Our Ref: BE/9/19/PL

**Town & Country Planning Act 1990 (as amended)
Town and Country Planning (Development Management Procedure) (England) Order 2015
Application for Planning Permission**

Development Steel portal frame hangar. This application is a Departure from the Development Plan.

Location Bognor Regis Flying Club LEC Airfield Railside Retail Park Shripney Road

Title: **Site plan and block plan for proposed Hangar @ LEC Airfield.
For Bognor Regis Flying Club. PO22 9FL**

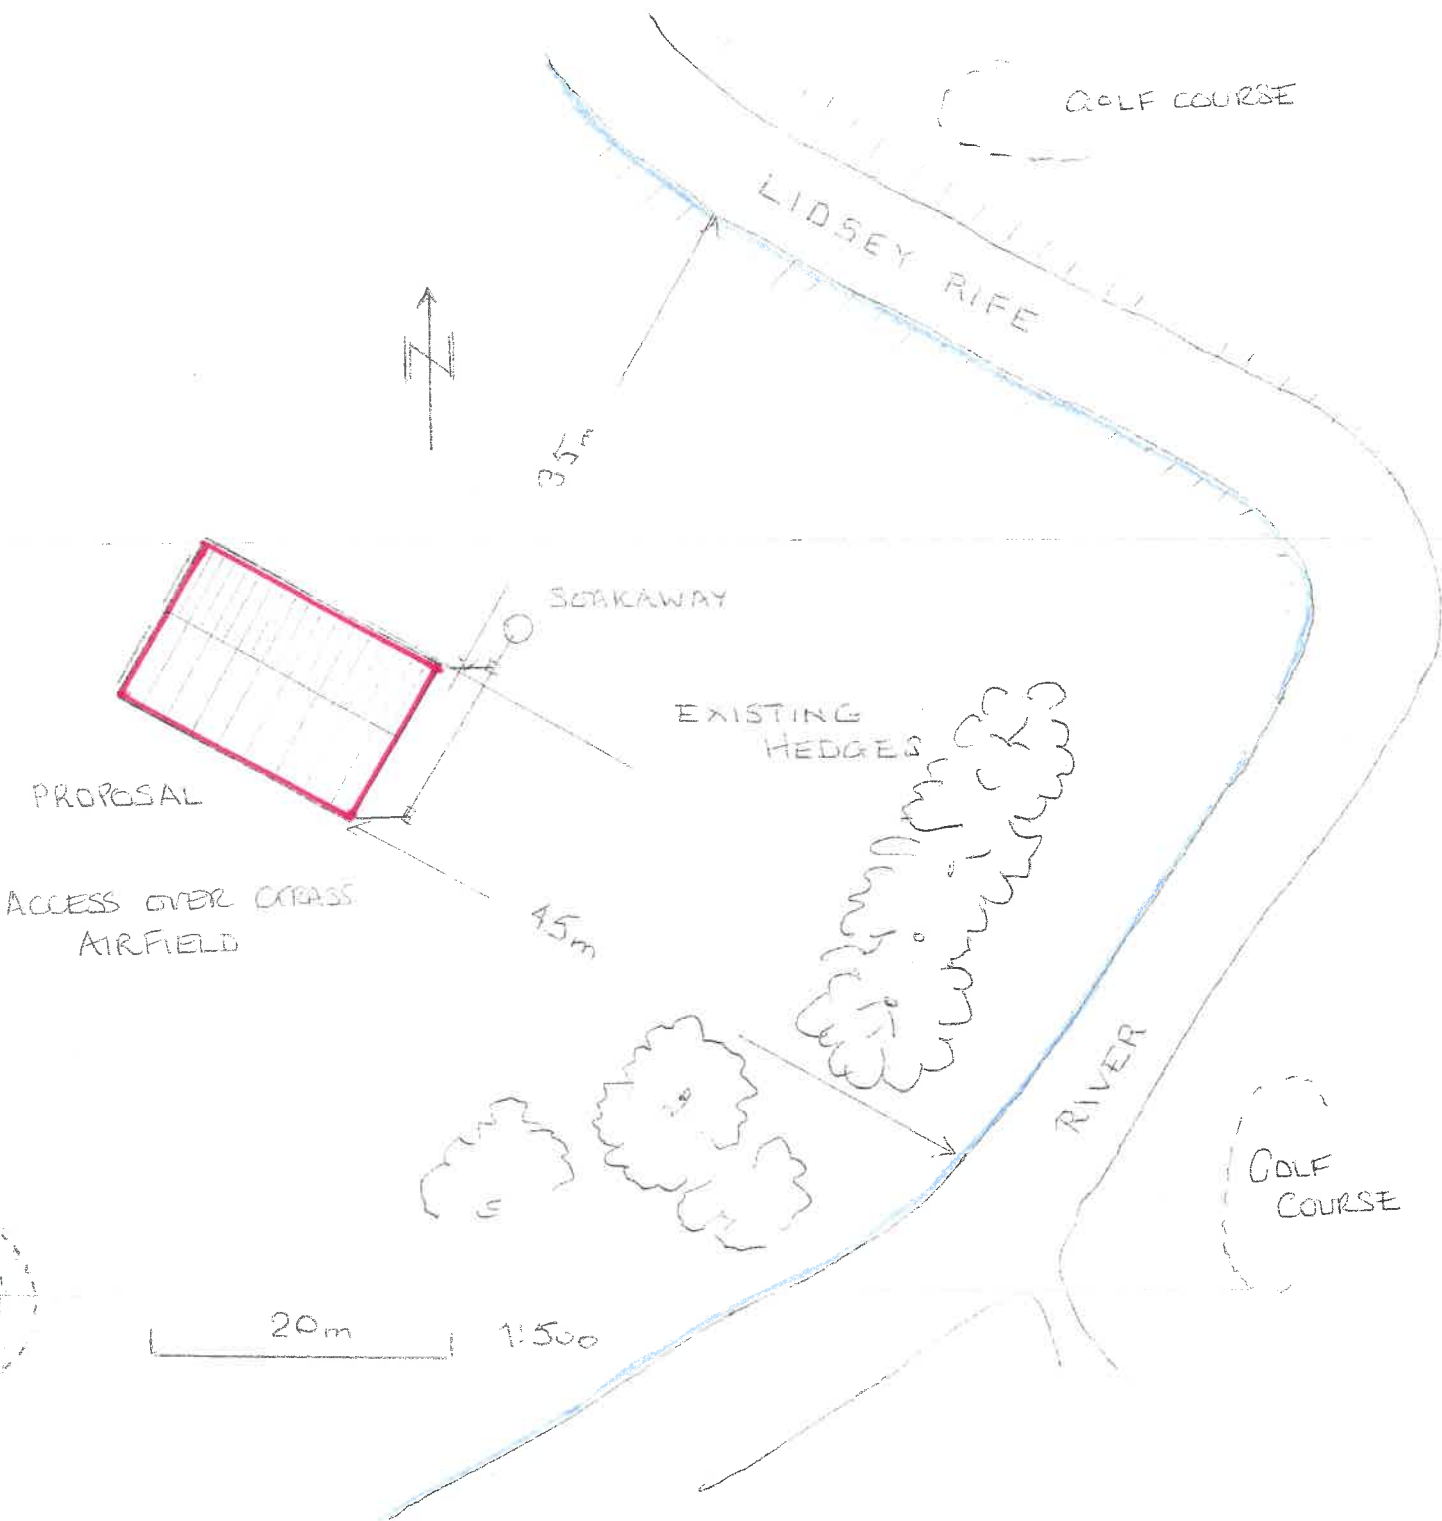
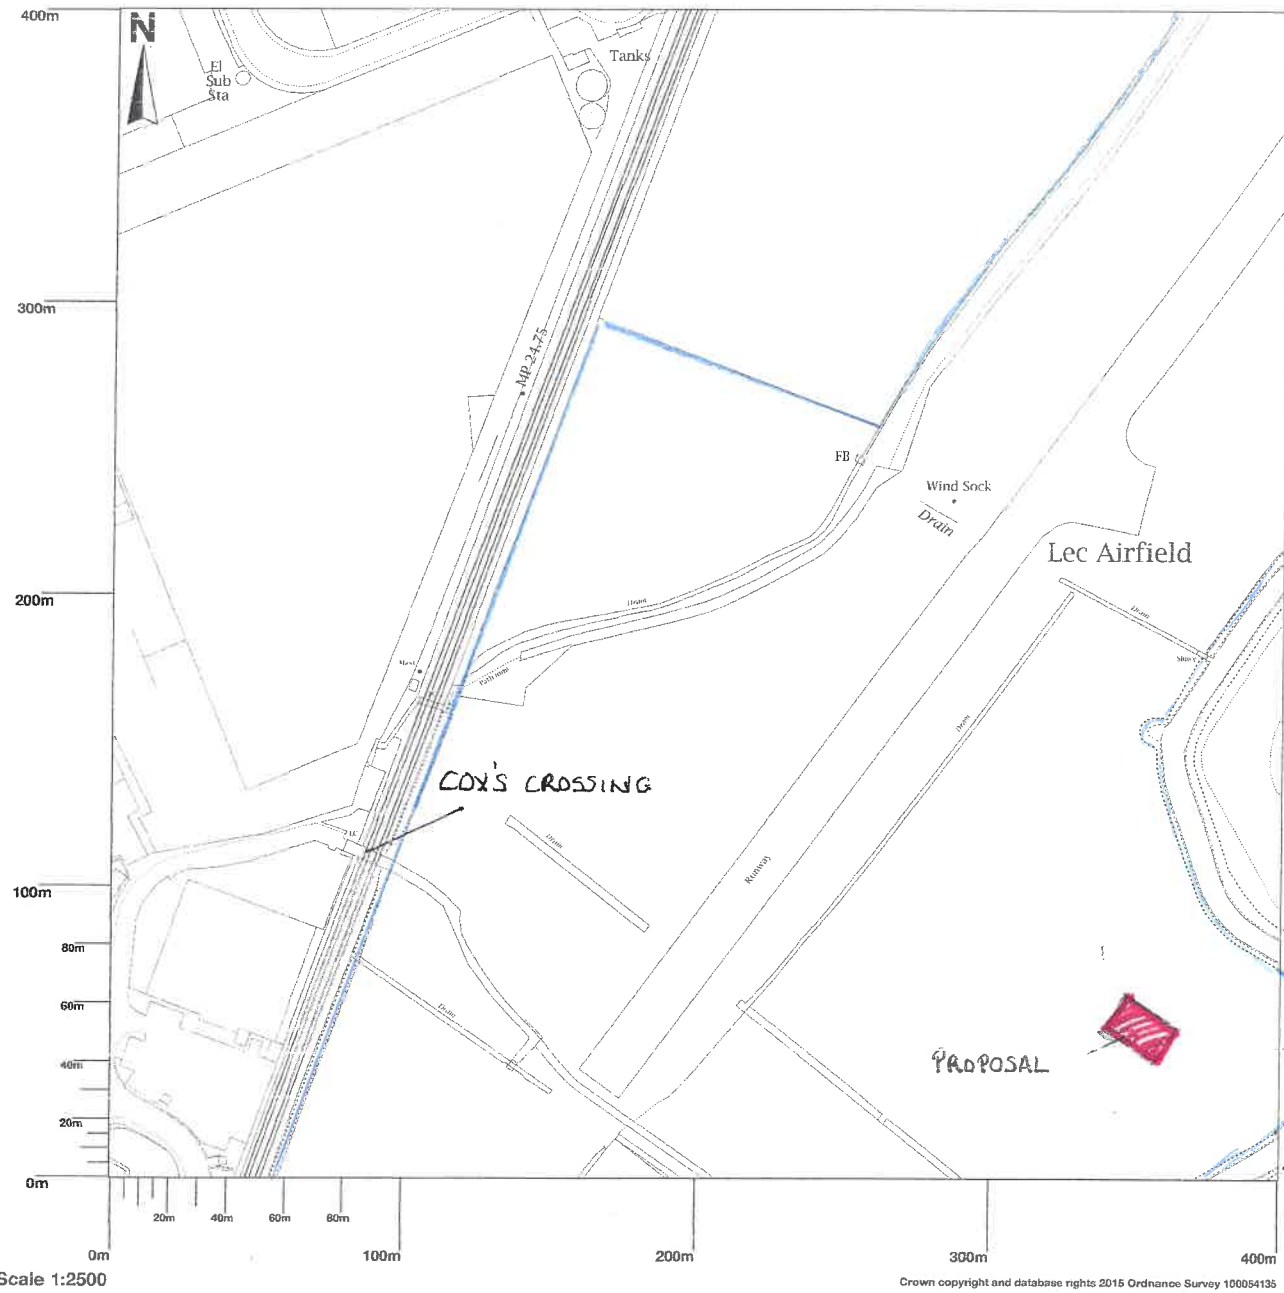
Location Plan Amend

Please provide 3 paper copies or one electronic copy of an amended location plan showing two named roads and a complete red edge for the site or take off the red edge of the site and only have the proposed building edged in red..

Block Plan Amend

Please submit 1 electronic or 3 paper copies of an amended block plan providing measurements from the proposal to the north, south and east boundaries.
